DELEGATED DECISION TO DETERMINE PLANNING APPLICATIONS

Reference No:	2024/62/93627/E
Site Address:	62, Moorcroft Drive, Dewsbury Moor, Dewsbury, WF13 4DY
Description:	Erection of extensions and front dormer window
Recommending Officer:	Faiza Bano

HOUSEHOLDER DELEGATED REPORT

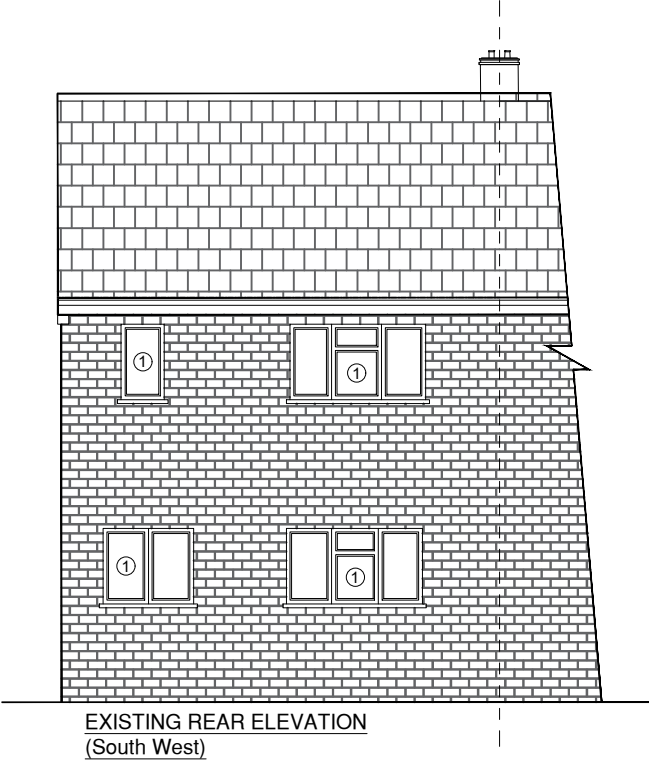
YES / NO	SUMMARY
Negotiations/Amendments during course of application	Yes	Request to amend the plans for the three-storey rear extension to a pitched roof from a flat roof.
Parish/Town Council comments sought (Kirkburton)	No	N/A

The original proposal included a flat-roof three storey rear extension. However, following discussions with officers, the agent submitted revised drawings featuring an amended roof form. The pitched roof was deemed more in keeping with the character of the area preferred from a visual amenity standpoint.
